Your Ref: OWPC19998
Our Ref: R/183/18/HH 01-08-2018
Please ask for:
Samantha Allen

Front ground floor extension, ridge extension to form gable w all over front extension, 2 new bedrooms & bathroom in roof space w ith dormer extension to side, 2 velux w indow s provided in existing roof slopes.

8 Acre Close Rustington

Thank you for your internet representation made on 18th September 2018 which has been recorded as '**an objection**' with the comments as follow s:

Drawing No JE./801.
Date:- July 2018.

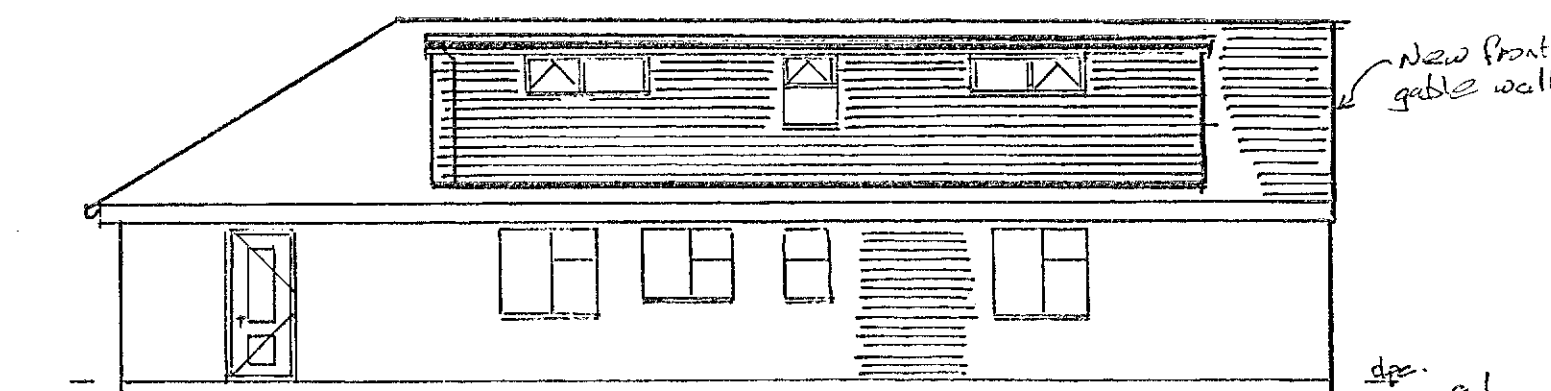
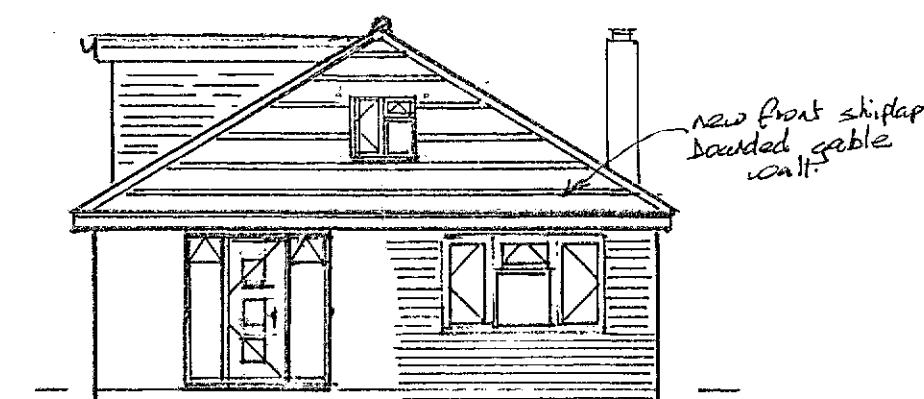
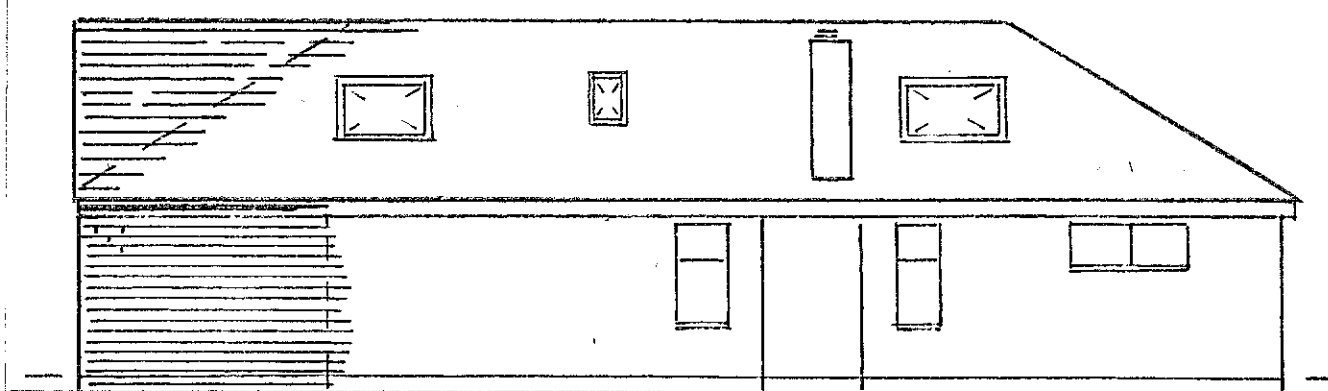
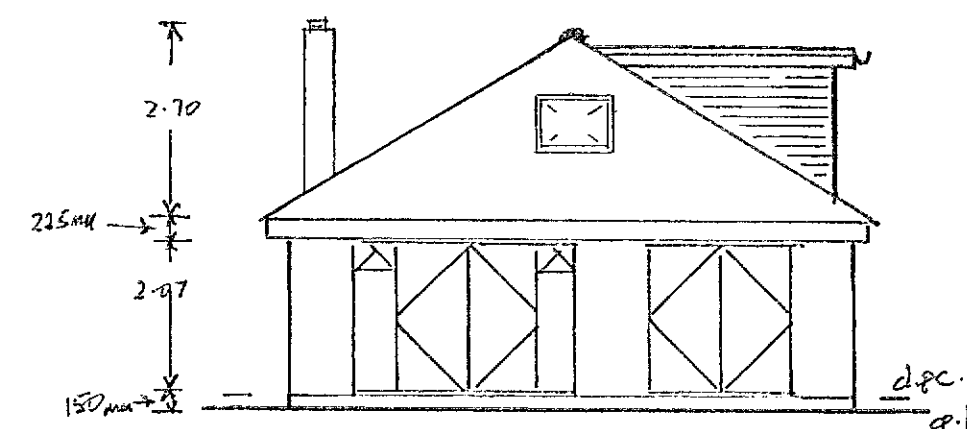
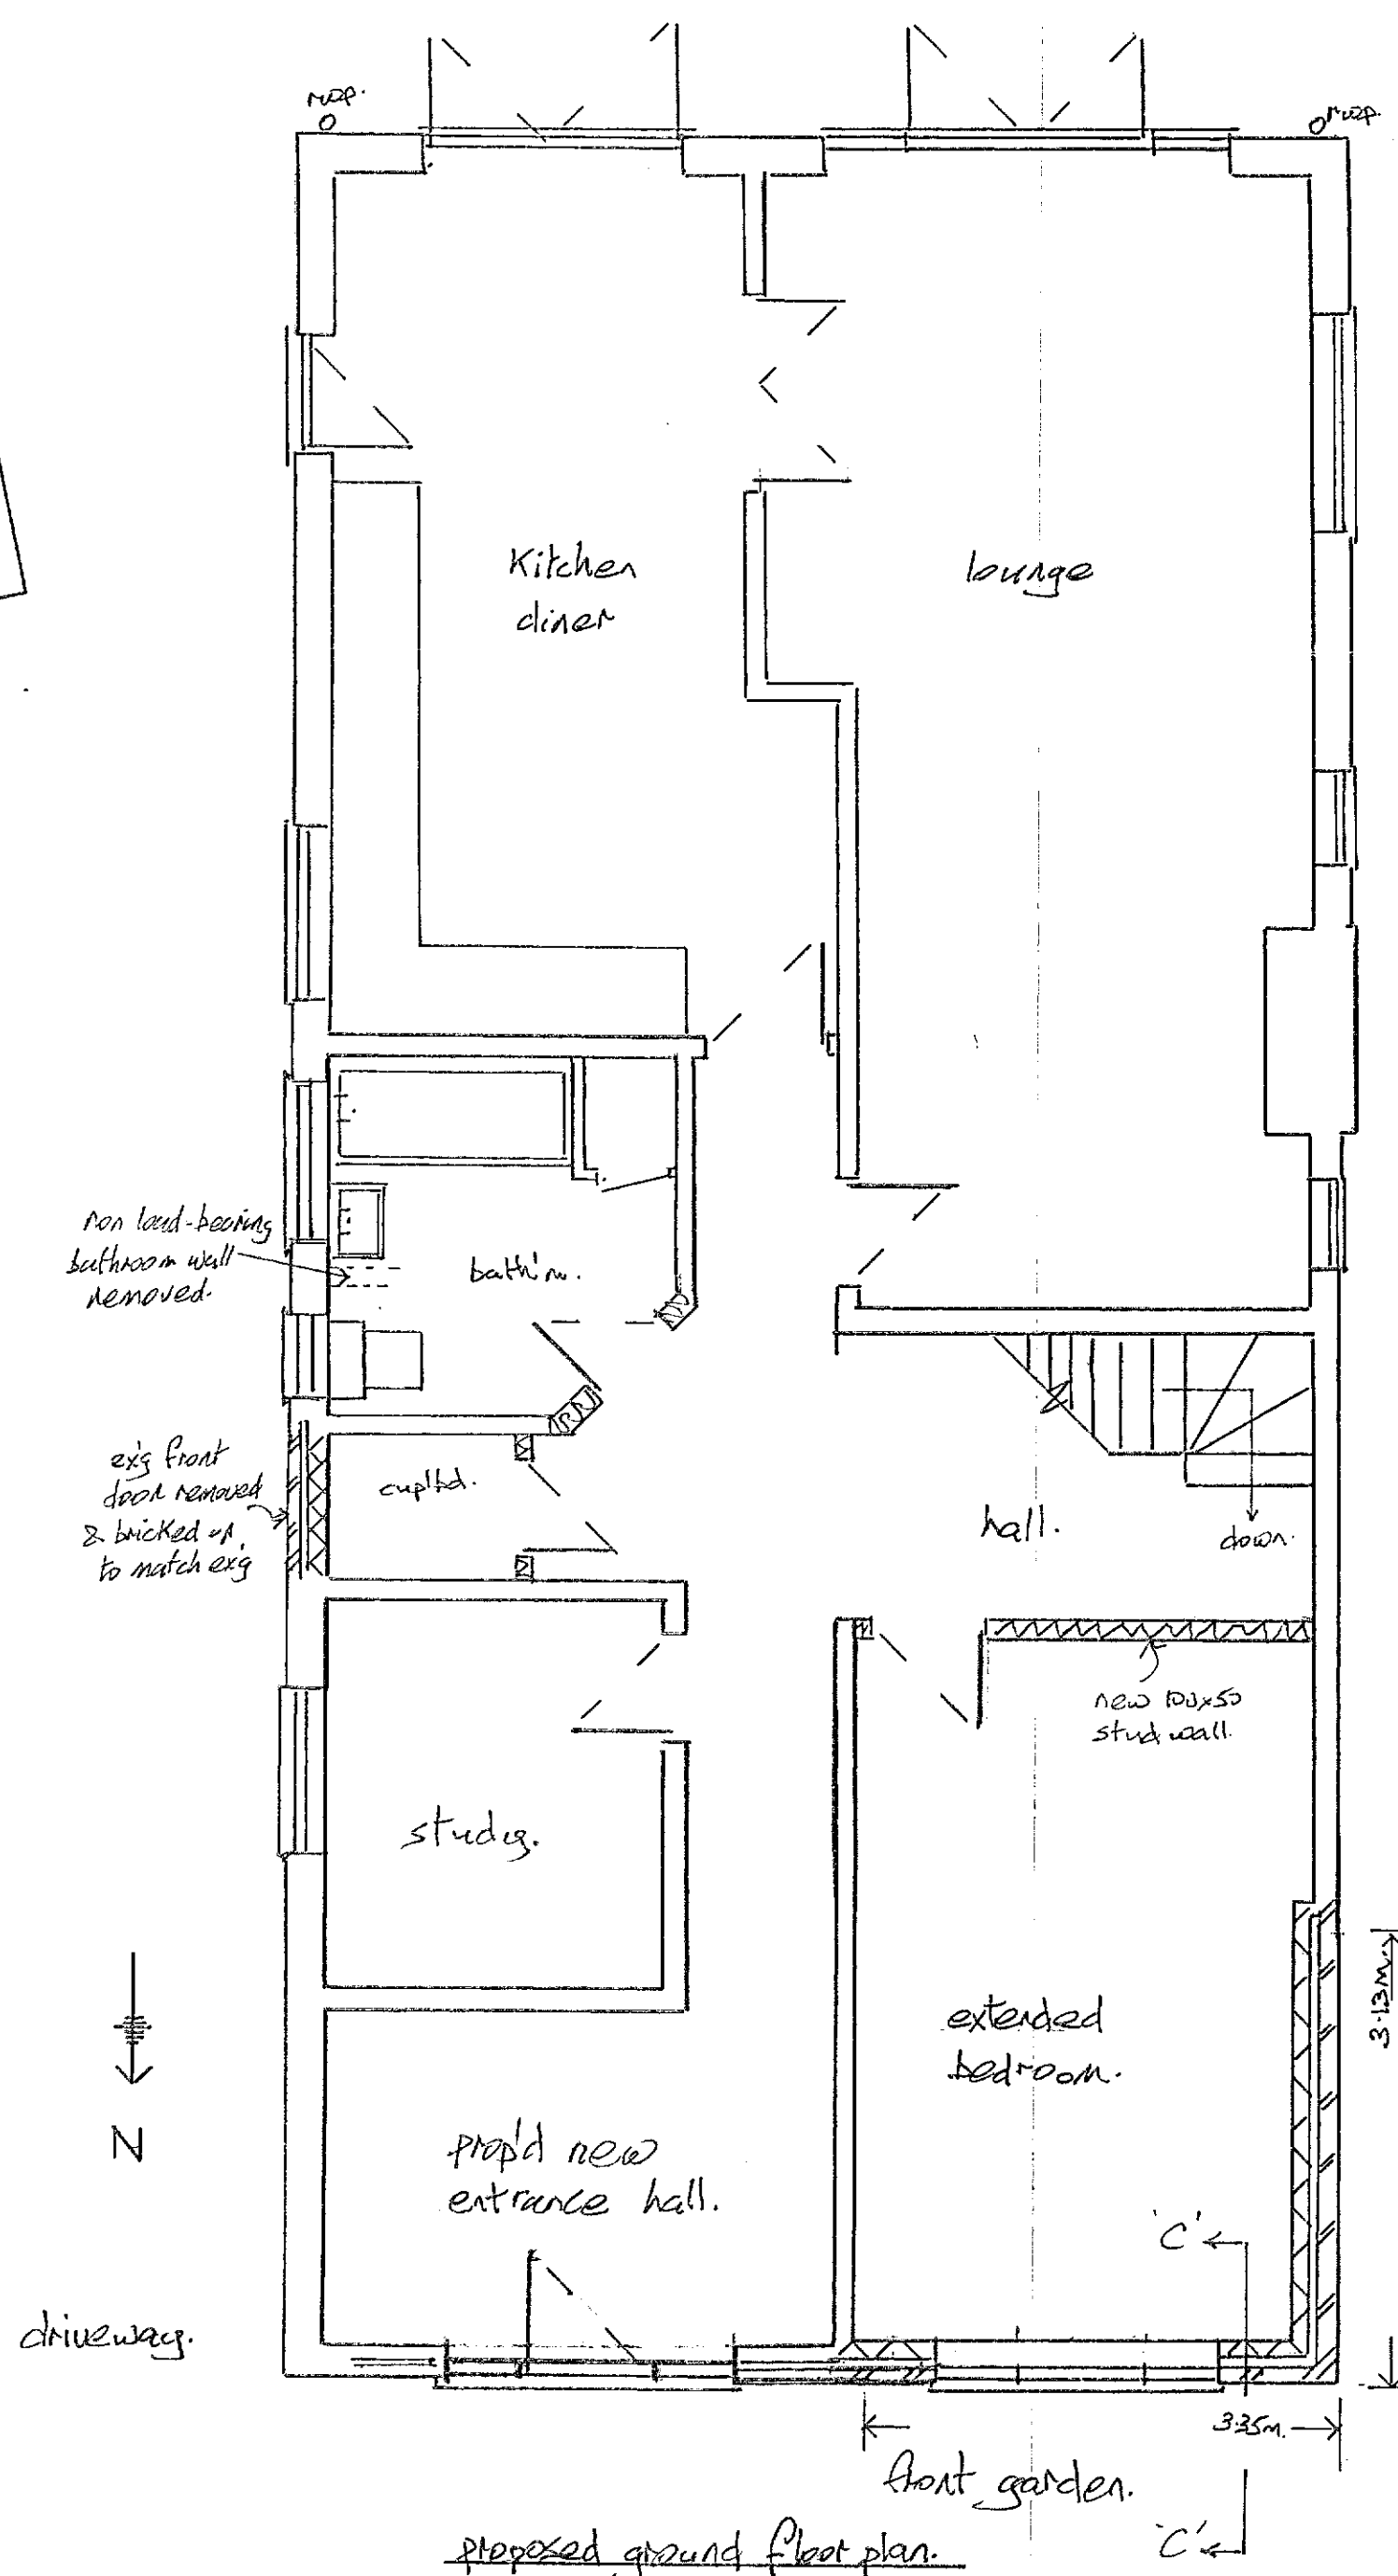
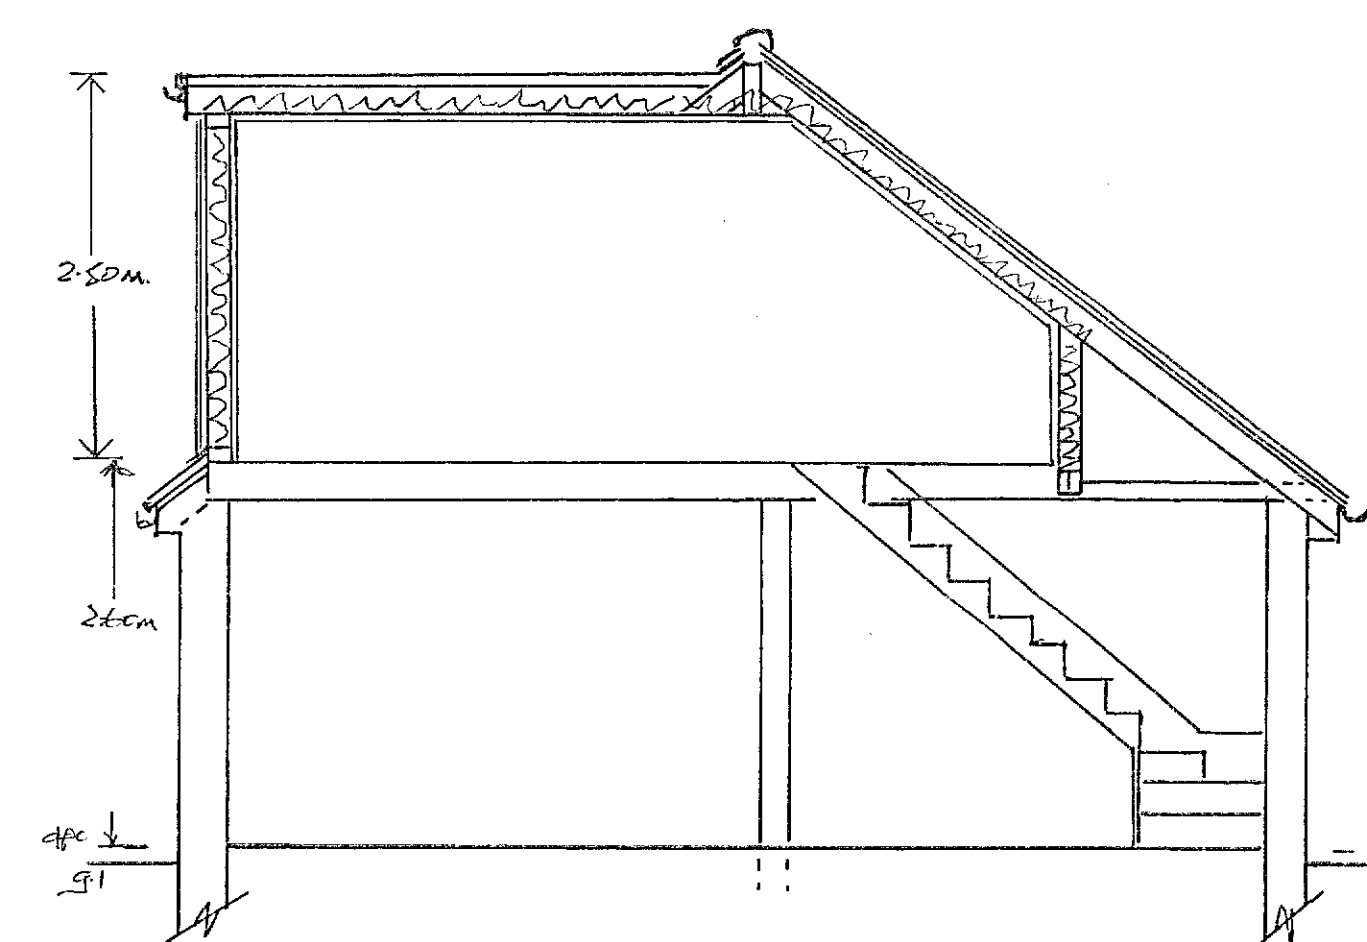
Acre Close has 10 detached traditionally built bungalows and having examined the planning drawing submitted I consider the scheme proposed for No 8 will be totally out of place and not in keeping with the adjacent buildings/surroundings. Furthermore the proposed construction of a long dormer to the east elevation complete with clear glazed windows facing over my lounge window will I suggest be an invasion of privacy.

The application states that two Velux windows are to be fitted in the existing roof structure. The drawing shows four Velux windows? Would appear each bedroom will have two Velux and one opening light window? More than adequate. Why not consider bedroom windows fitted on front and rear elevations therefore not overlooking adjacent properties
